10 October 2025
Ref 24526

SSD-77825469
2-16 POCKLEY AVENUE, ROSEVILLE
TRAFFIC AND PARKING MATTERS

Department of Planning, Housing and Infrastructure Response

Ku-ring-gai Council Response

04.03 Building Ground Floor Plan

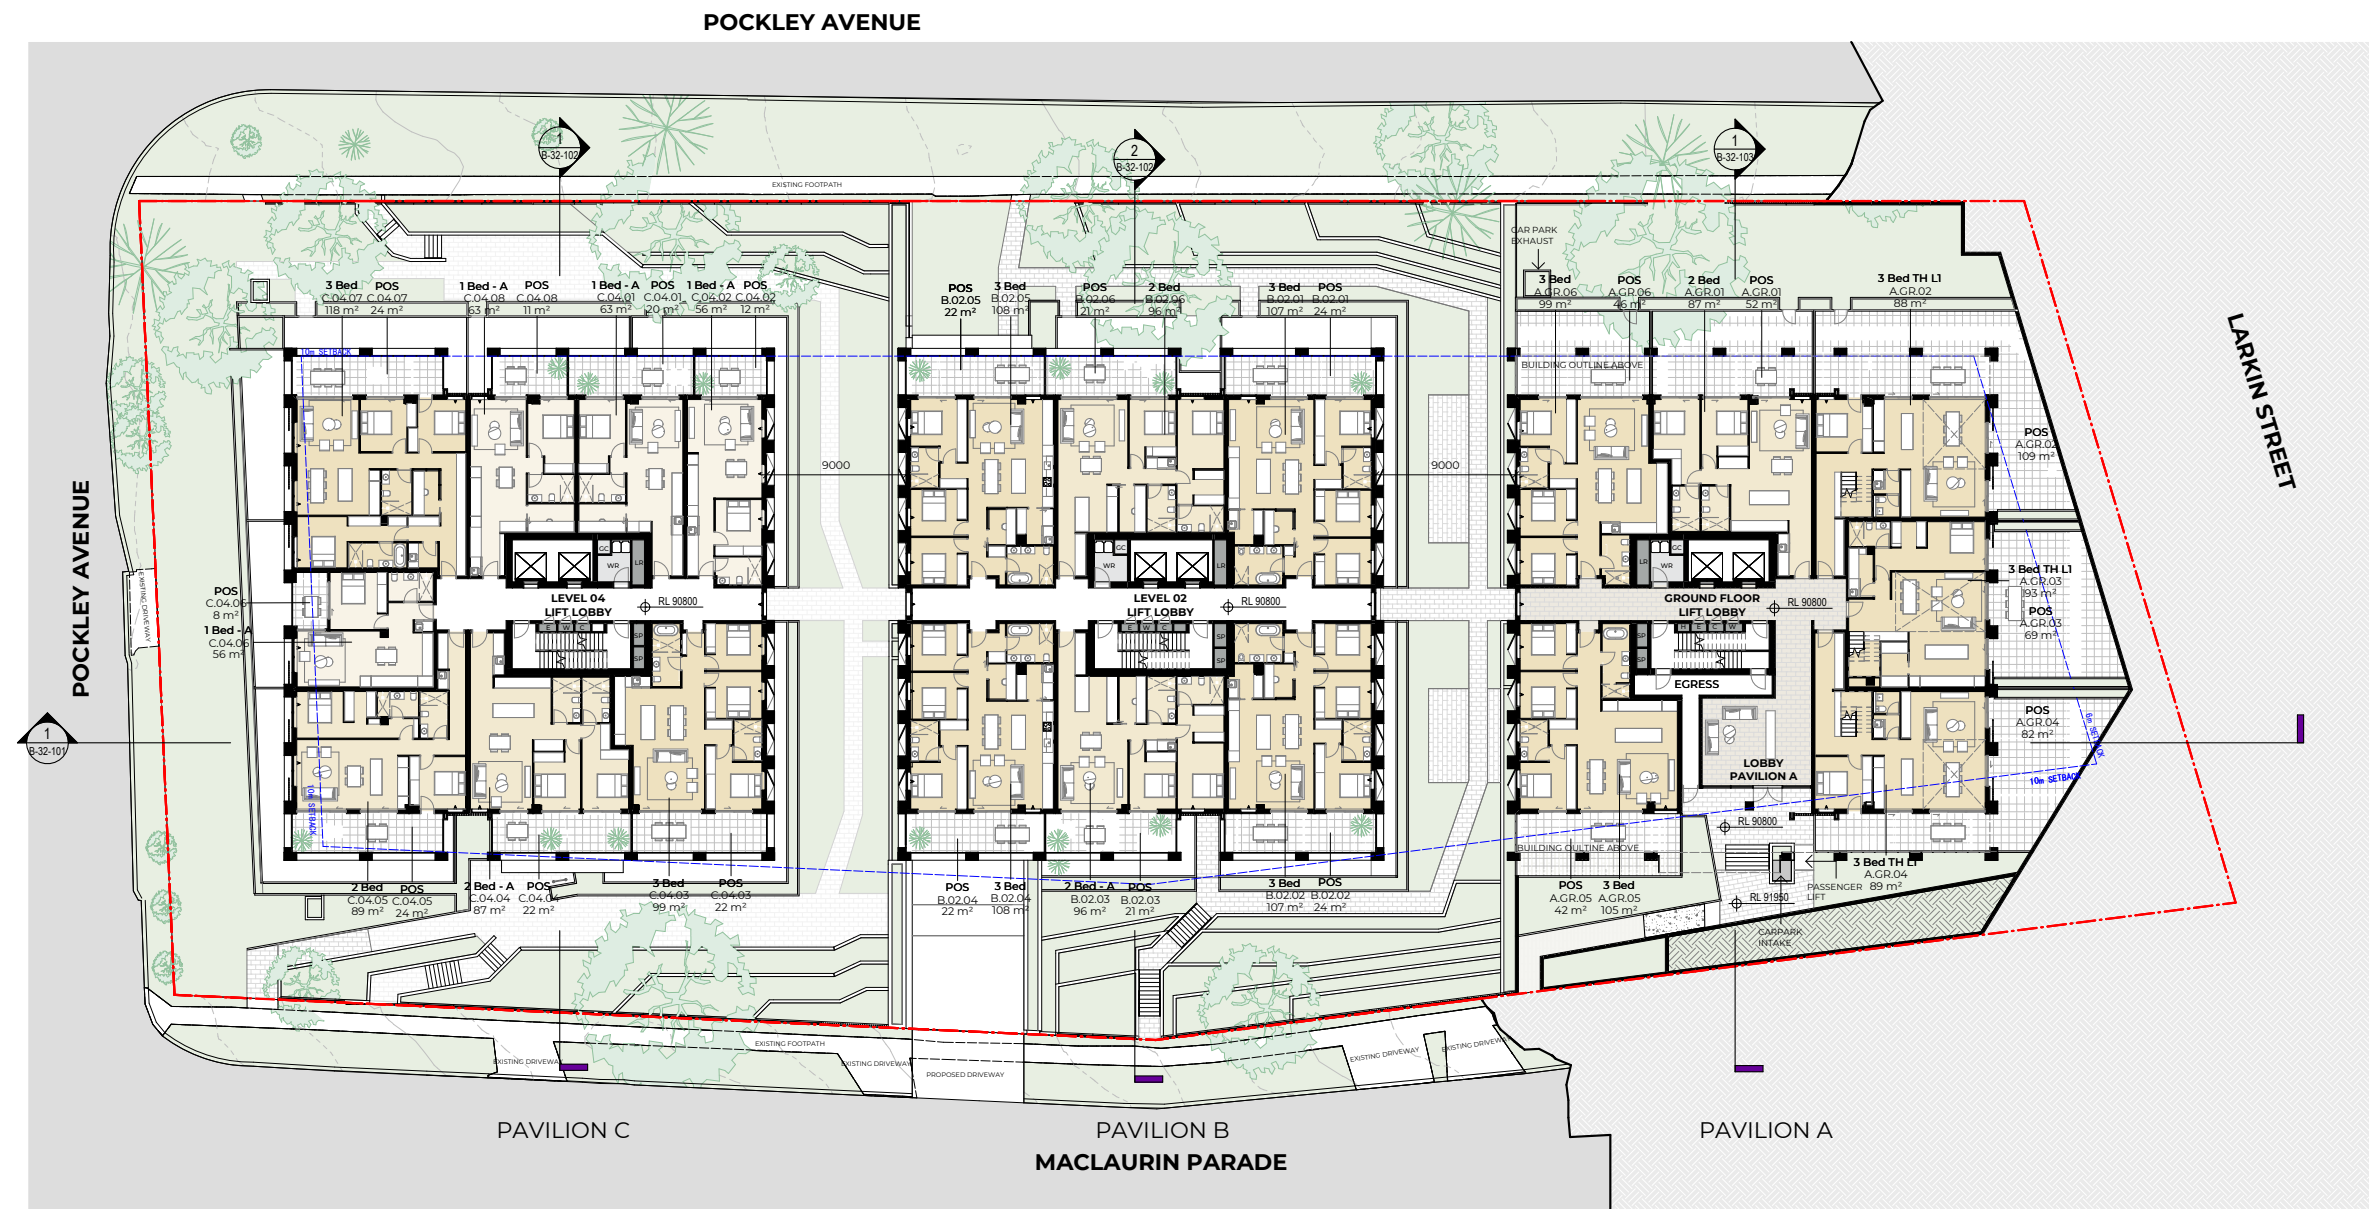
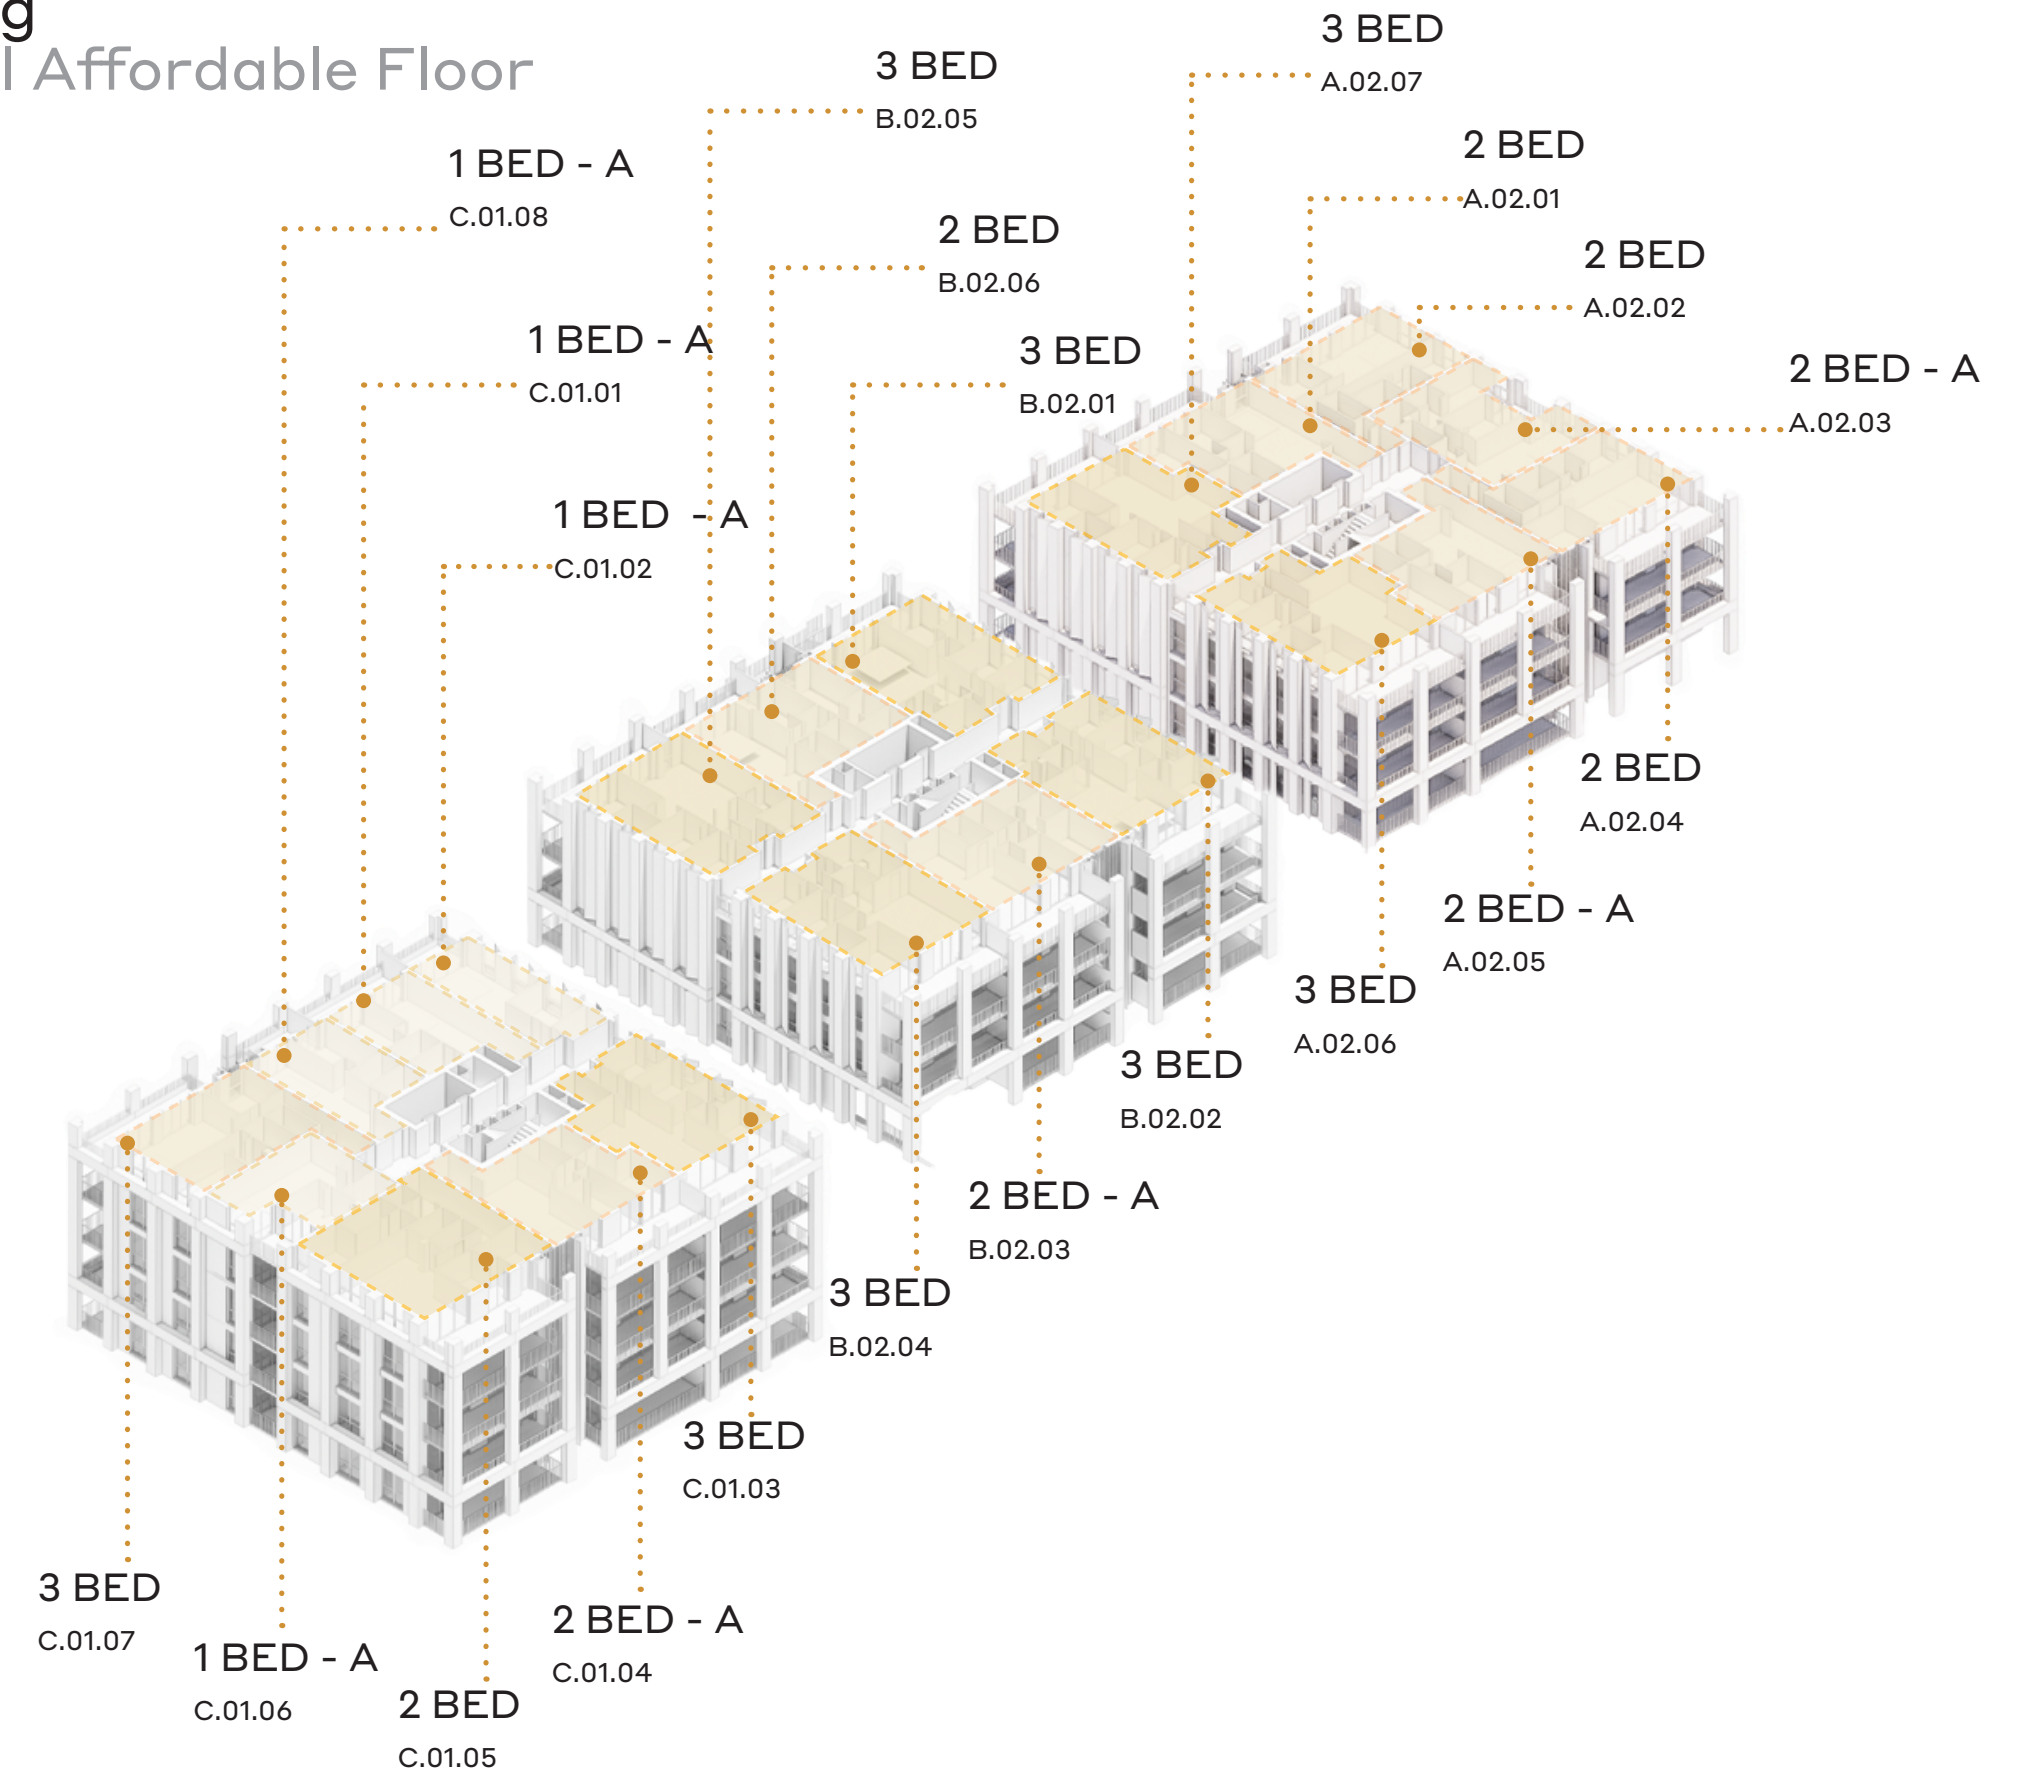
9. *Some of the visitor bicycle parking devices from Pavilion B and C are to be re-distributed to the Pavilion A Lobby*

As requested, the plans have been modified to redistribute some of the visitor bicycle parking from Pavilion B and C to the Pavilion A lobby.
